Fire Marshal Division

March 11, 2021

RE: MiCancun
115 S. Raleigh St.
Angier, NC 27501

Application Number FMFW2103-0002

**1 LIFE SAFETY PLAN**  
 SCALE: 1/2" = 1'-0"

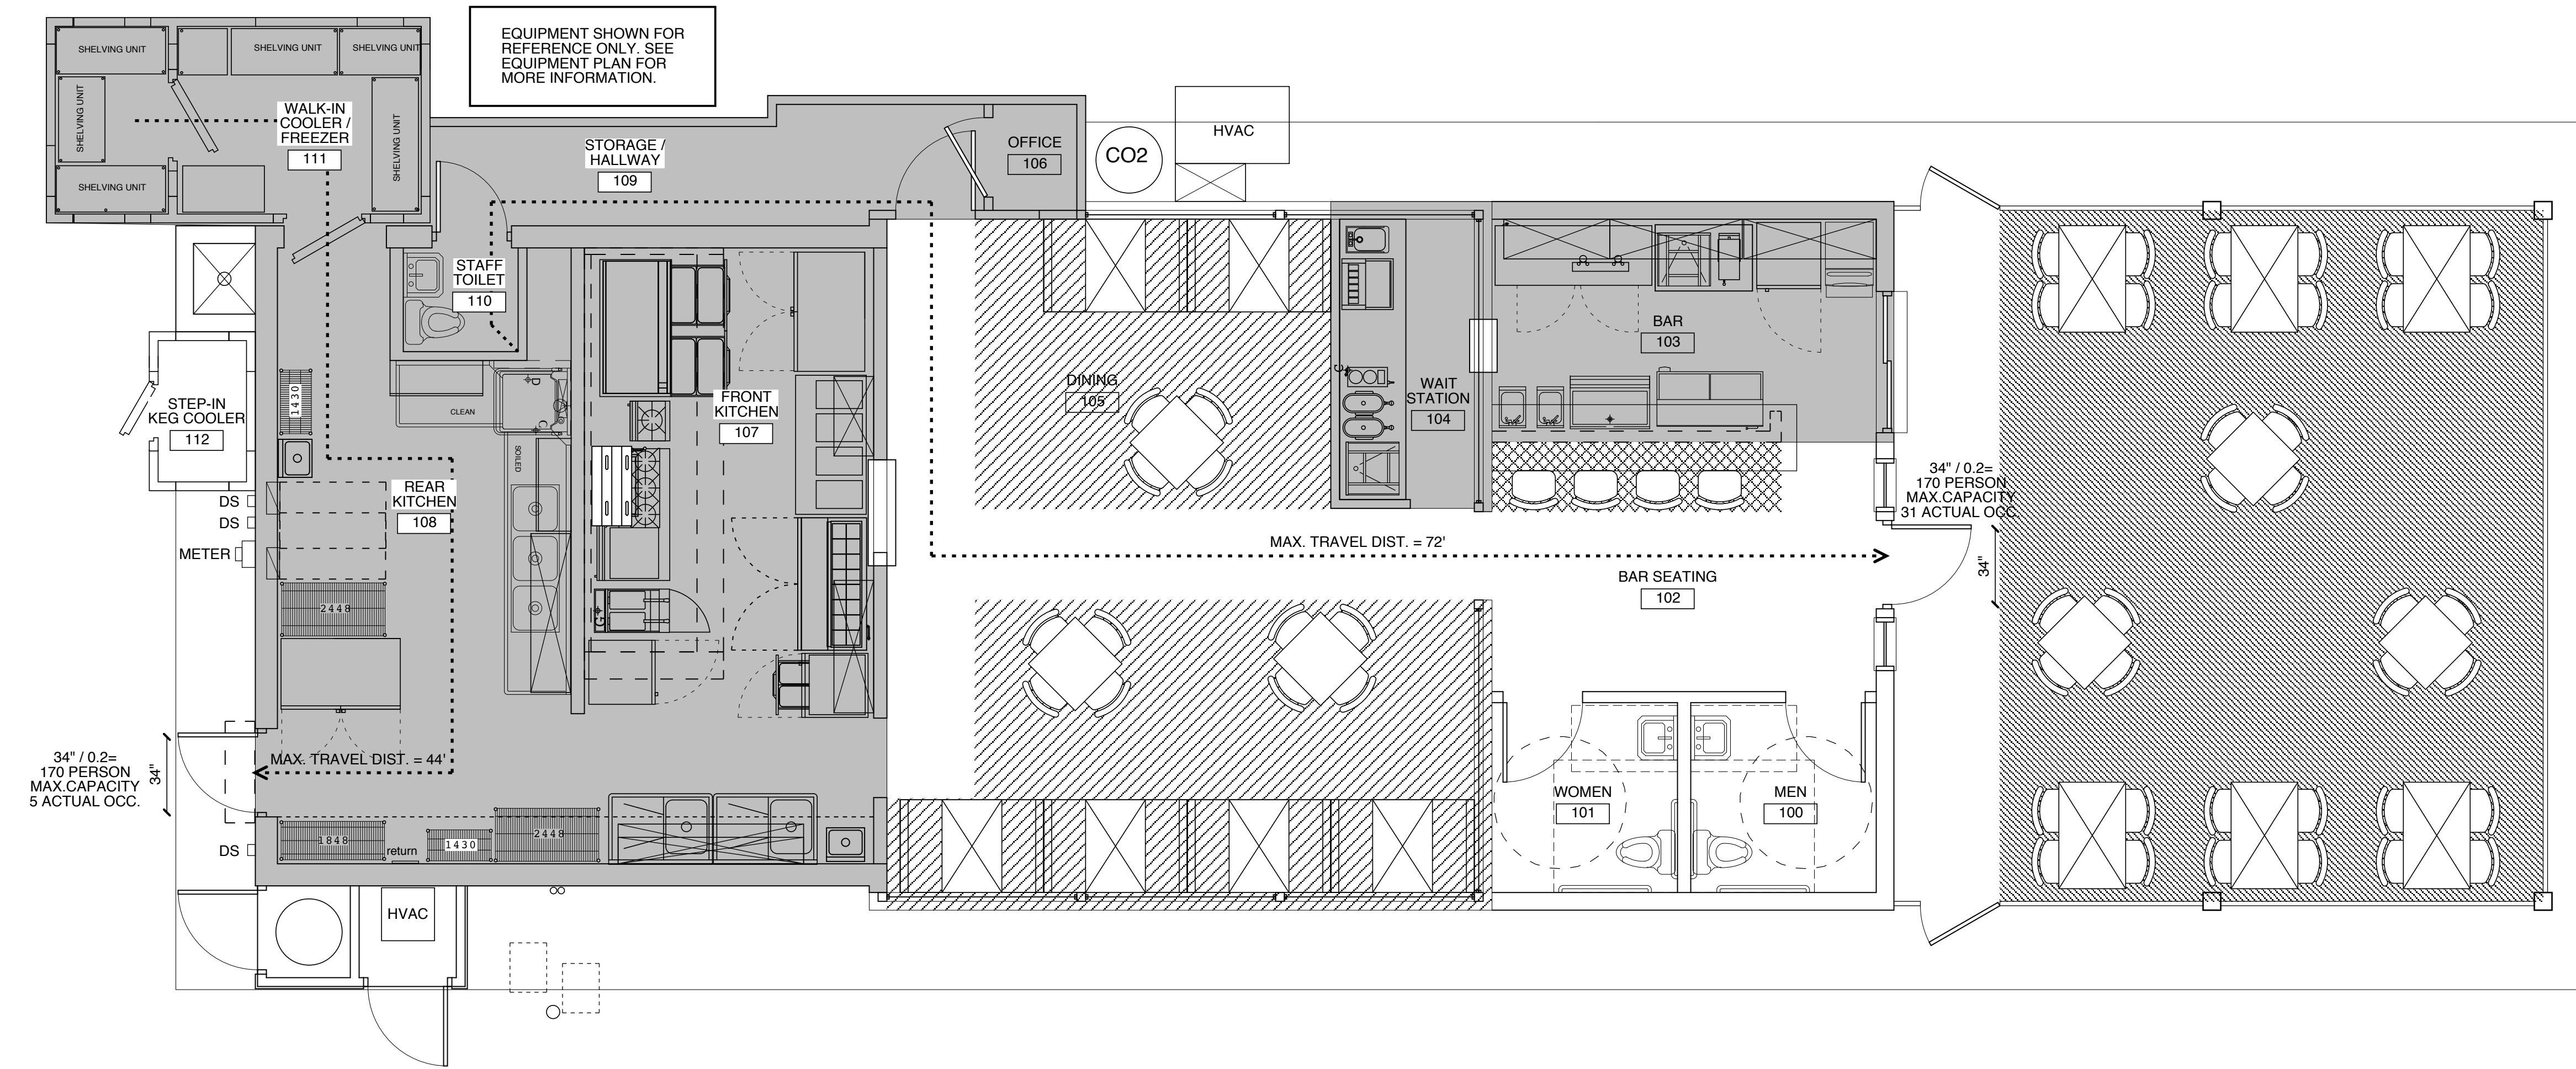
- **Panic Hardware**
 - UL 305 listed panic hardware is required on exit doors serving a room/space with an occupant load >50, also indicated on Building code summary.

UL 300 HOOD FIRE SUPPRESSION SYSTEM

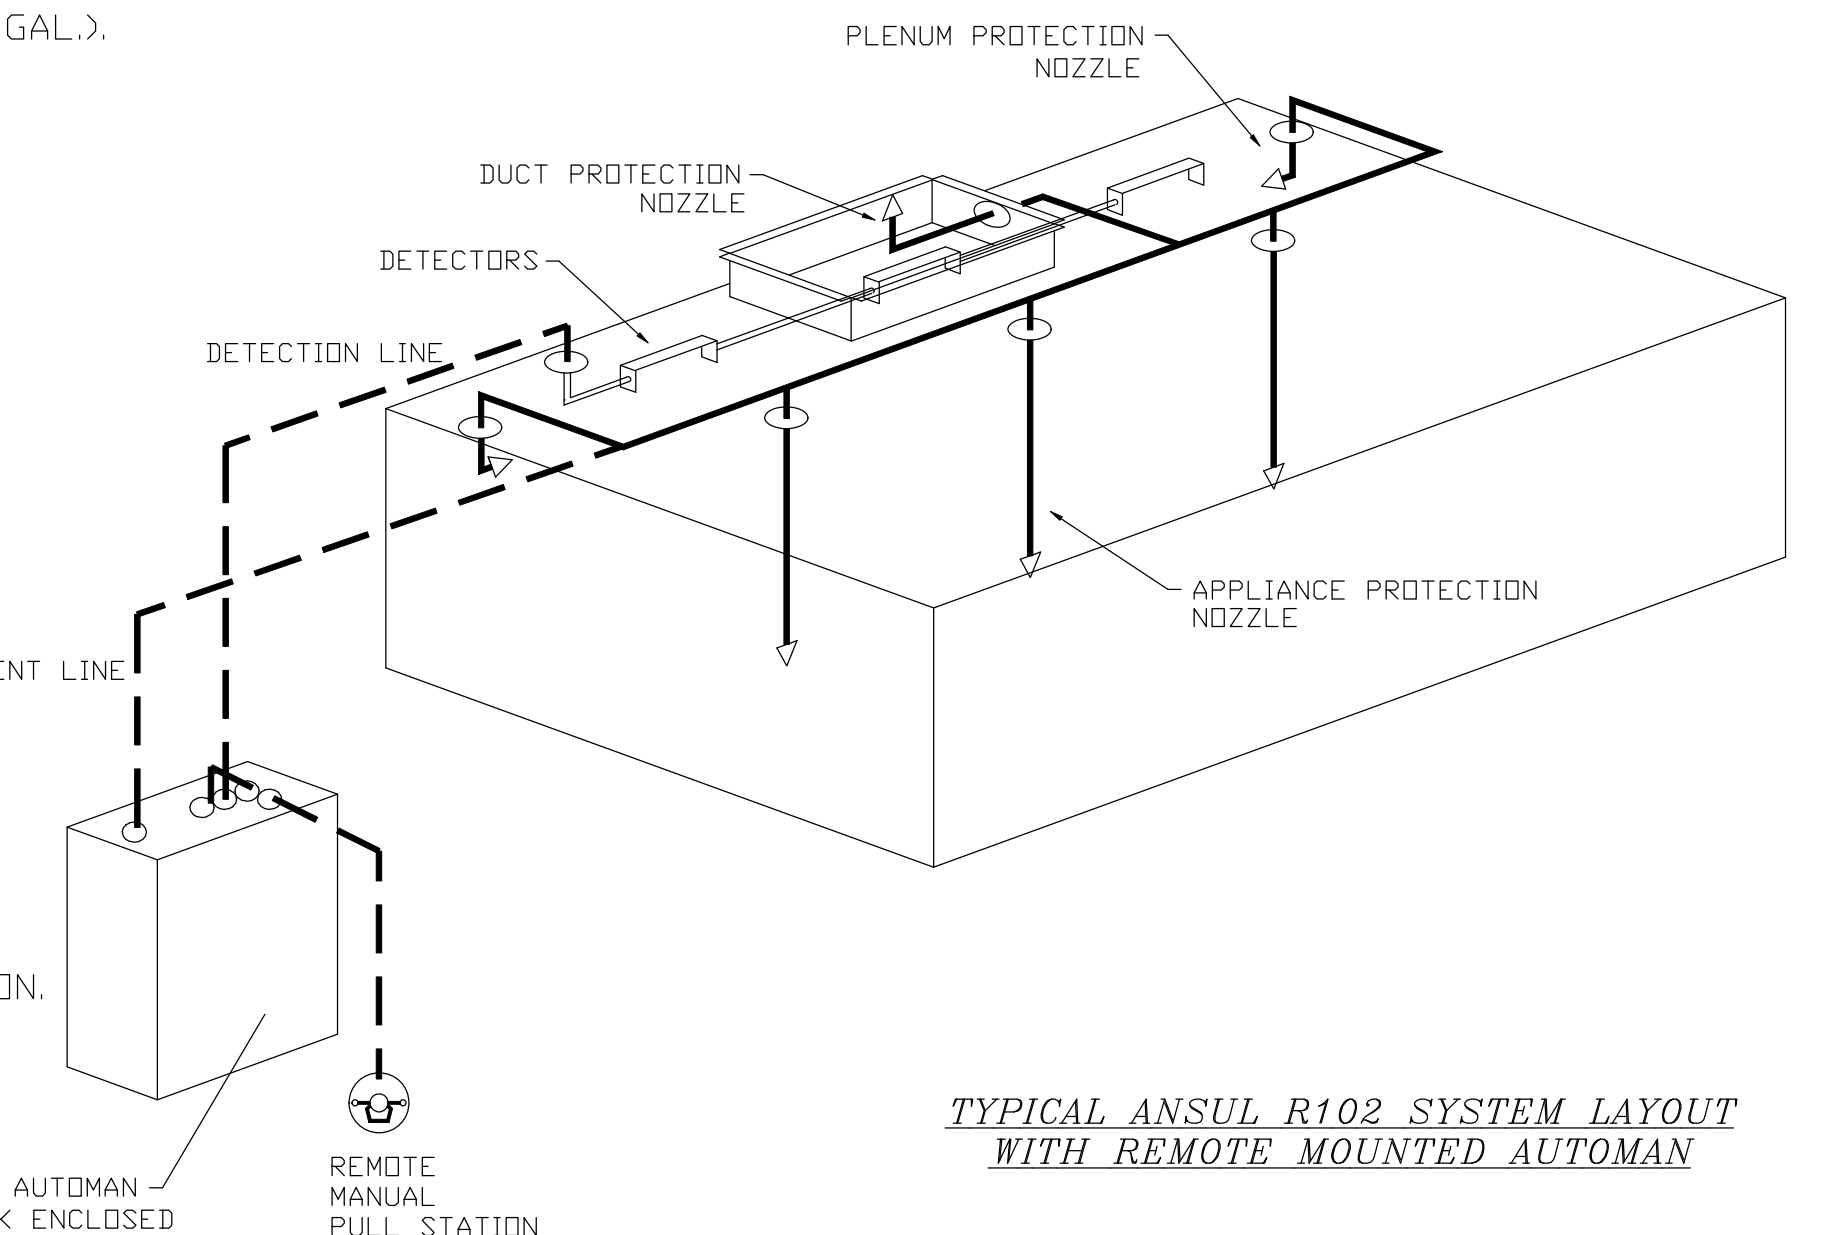
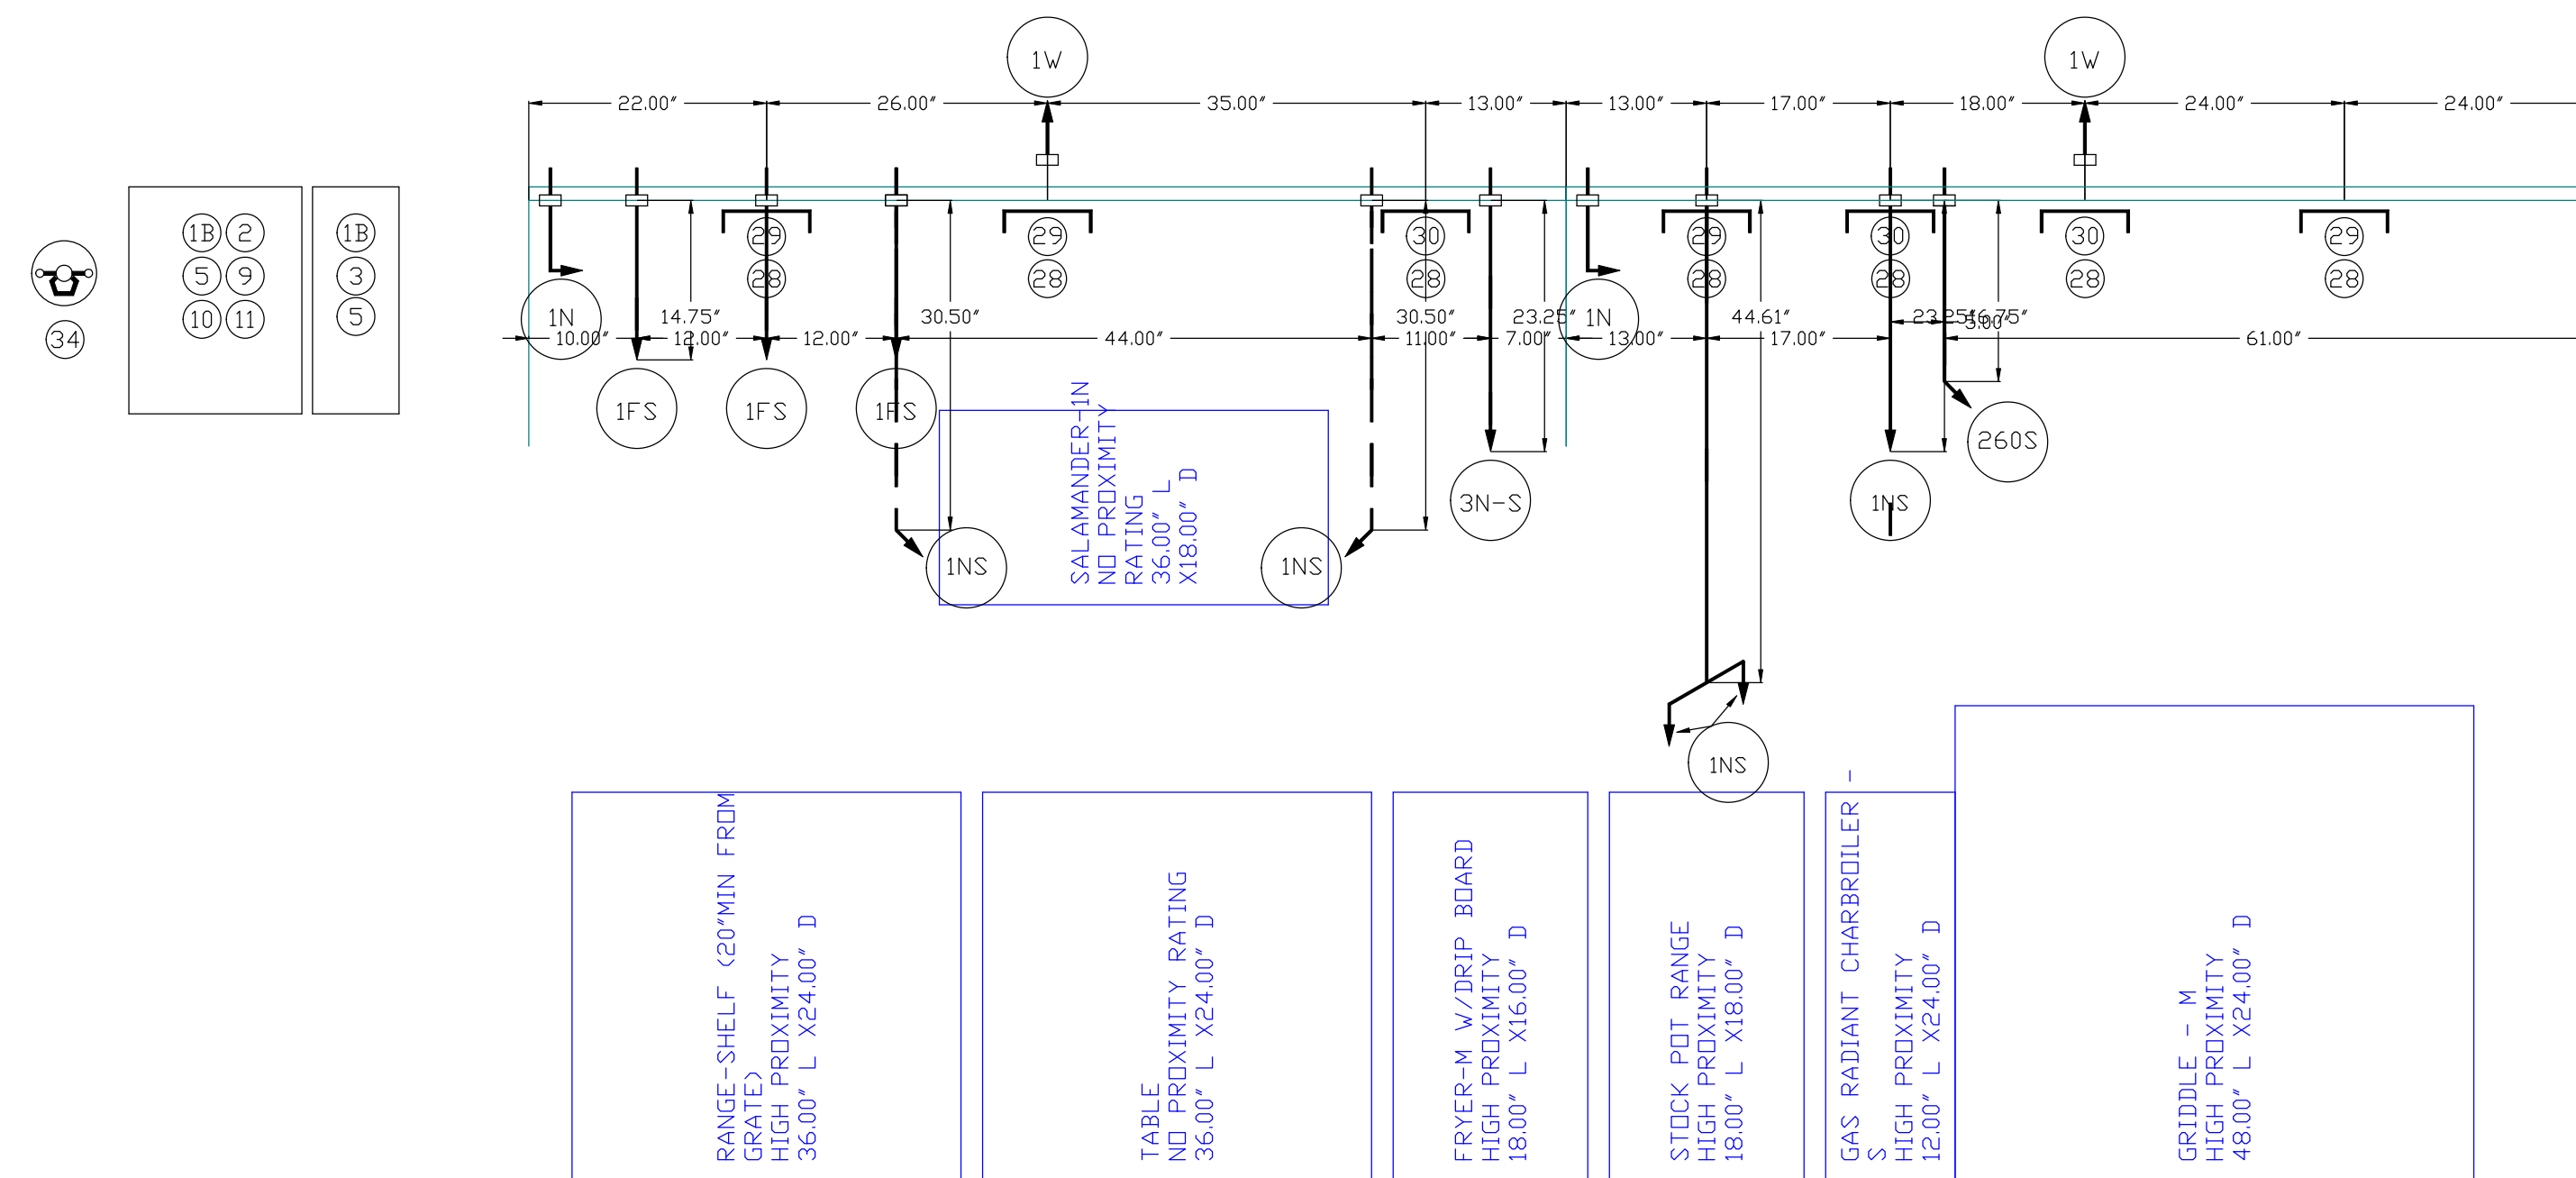
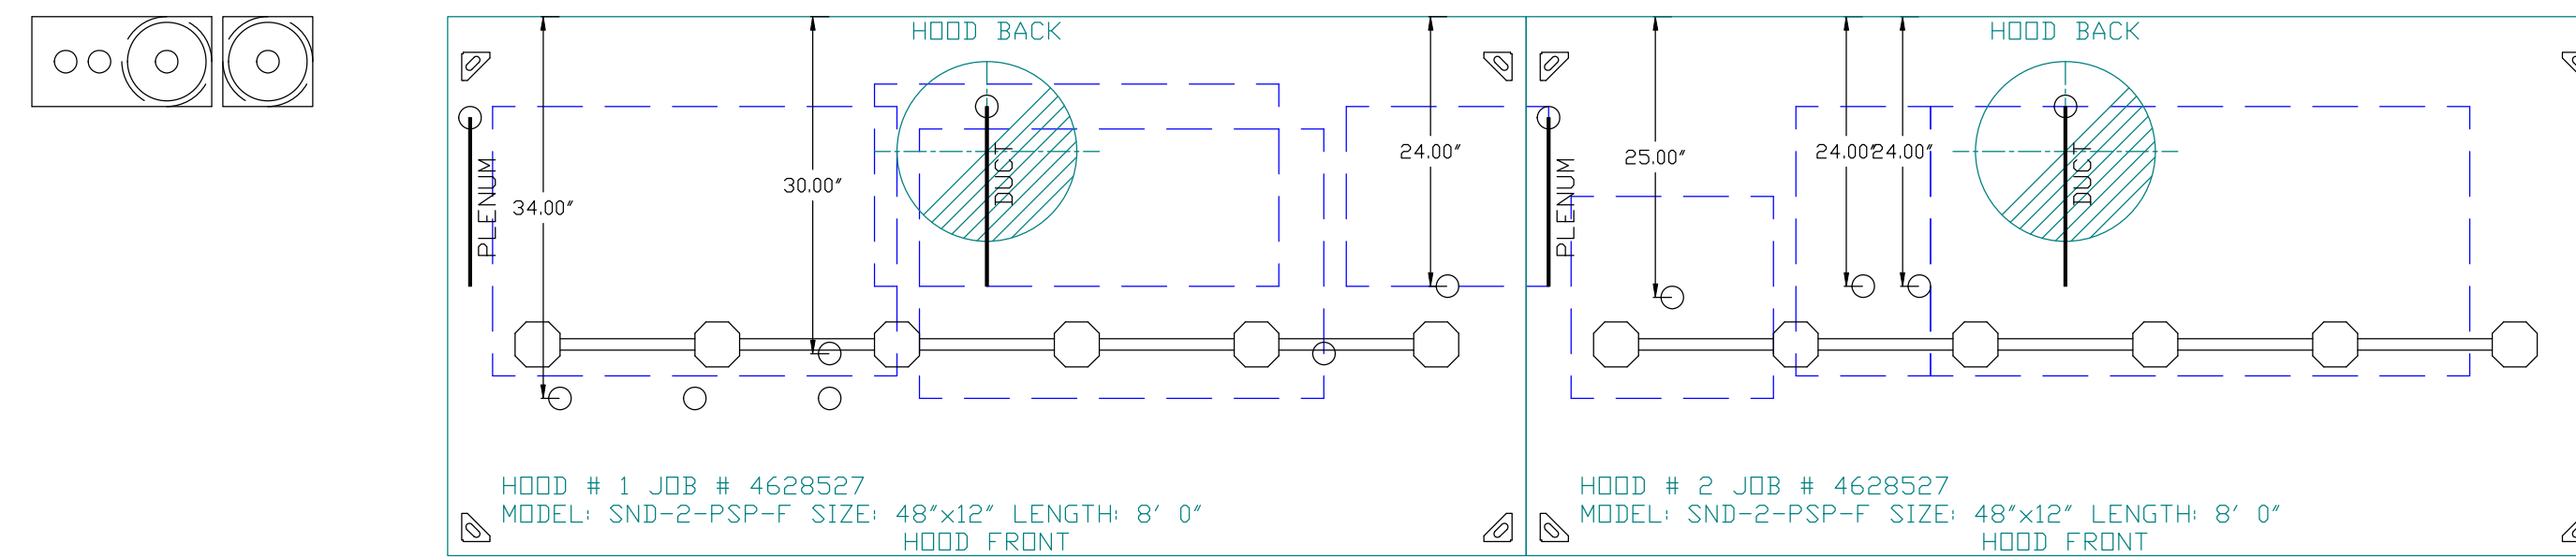
- **Acceptance Test of Commercial Hood System**
 - Submit kitchen hood fire suppression system plans and specifications for approval prior to installation.

- An acceptance test will be conducted by the Fire Marshal's office once system has been installed and pre-tested.
 - Installation shall be per architectural and system submittals and compliant with NFPA-17A.

- **Manual system operation of Commercial Hood System**
 - A manual actuation device shall be located at or near a means of egress from the cooking area, a minimum of 10 feet (3048 mm) and a maximum of 20 feet (6096 mm) from the kitchen exhaust system. The manual actuation device shall be located a minimum of 4.5 feet (1372 mm) and a maximum of 5 feet (1524 mm) above the floor. The manual actuation shall require a maximum force of 40 pounds (178 N) and a maximum movement of 14 inches (356 mm) to actuate the fire suppression system.

- **System Interconnection of Commercial Hood System**
 - The actuation of the fire suppression system shall automatically shut down the fuel or electrical power supply to the cooking equipment. The fuel and electrical supply reset shall be manual. The fire suppression system must be connected to the fire alarm system if applicable.
